CITY OF ALBUQUERQUE

April 3, 2012

**Re: US New Mexico Federal Credit Union
Tract 5, Andalucia at La Luz
Conceptual Grading and Drainage Plan
Engineer's Stamp Date 3/26/2012 (E12/D015D1)**

SECTION B-B
NOT TO SCALE

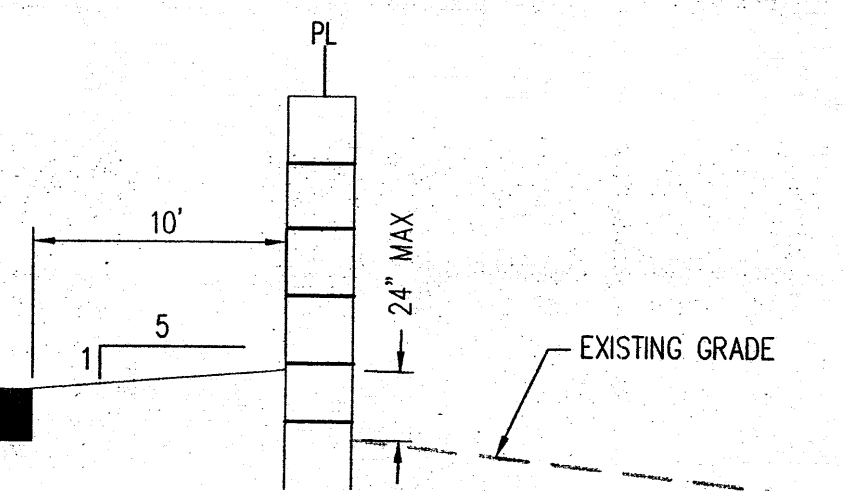
- Hydrology requires more information on whether the property owners will permit Pond A to be modified. Will the Temporary Pond become permanent?
- Grout is not a preferred method for plugging the pipe, because there is the possibility of debris in the downstream public storm drain.
- The onsite inlets may need to be relocated.
- Does the wall in section B-B continue to the east property line?
